# M25 junction 10/A3 Wisley interchange TR010030 9.5 DCO Application Errata Schedule

#### 9.5 DCO APPLICATION ERRATA SCHEDULE

<b>Regulation Number:</b>	Regulation 5(2)(q)
<b>Planning Inspectorate Scheme Reference</b>	TR010030
<b>Additional Submission Reference</b>	TR010030/9.5 (5)
<b>Author:</b>	M25 junction 10/A3 Wisley interchange project team, Highways England and Atkins

SHEET 20 OF 31

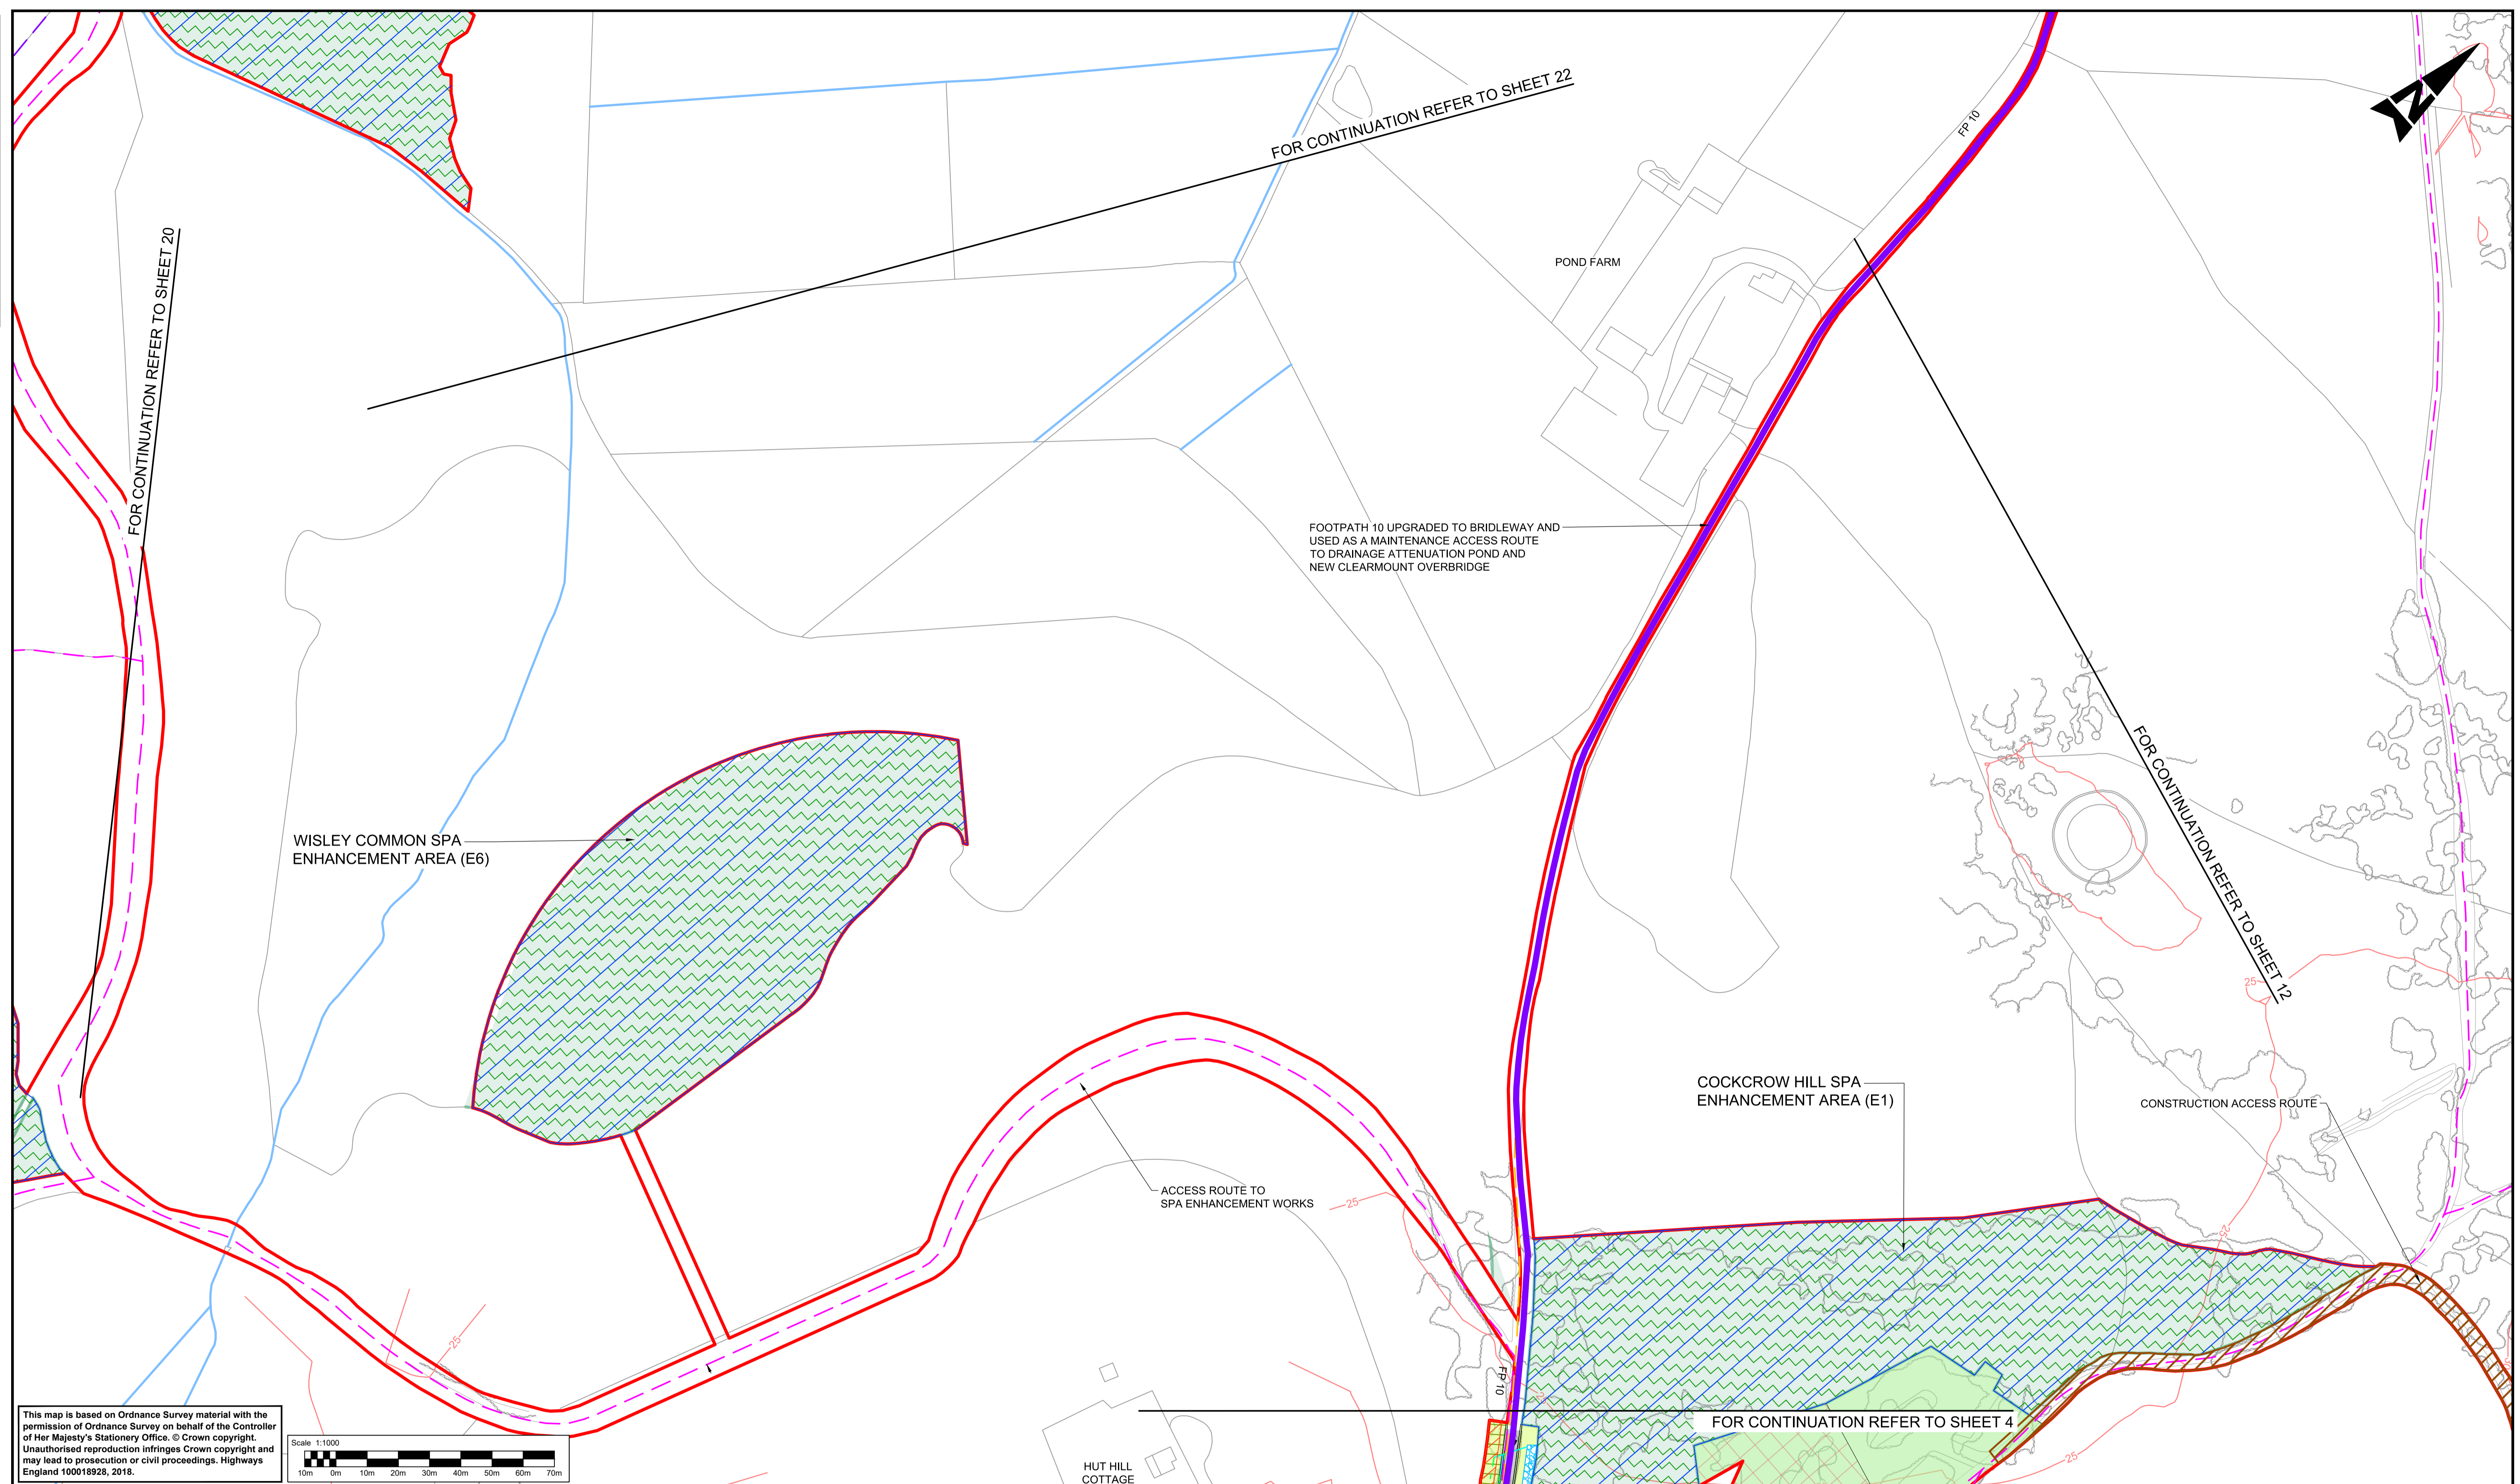
AS-017	Transferring Historic Common Land and Exchange Land	Appendix A	The Polygons labelled as Land Taken from Open Space are not numbered.	This is not required to be updated as it does not detract from the ability to read the plan.
AS-019	9.3 Orange Land Plans	Sheet 20 of 31	Sheet 20 does not contain an Inset Plan	This is not required to be updated as it does not detract from the ability to read the plan.
<b>Deadline 2</b>				
APP-016	2.11 Nature Conservation Sites and Features Plans	Nature Conservation Sites and Features Plans Sheet 1 and 2 of 9	The Wisley Fields SNCI site boundary shown on Sheet 1 and 2 of the plans is incorrect.	The correct boundary is displayed on the Environmental Statement: Chapter 7 Biodiversity Figures 1 of 3 [AS-013]. Please refer to this boundary.
APP-053	6.3 Environmental	8.5.3	Section 8.5.3 incorrectly references	The correct references are
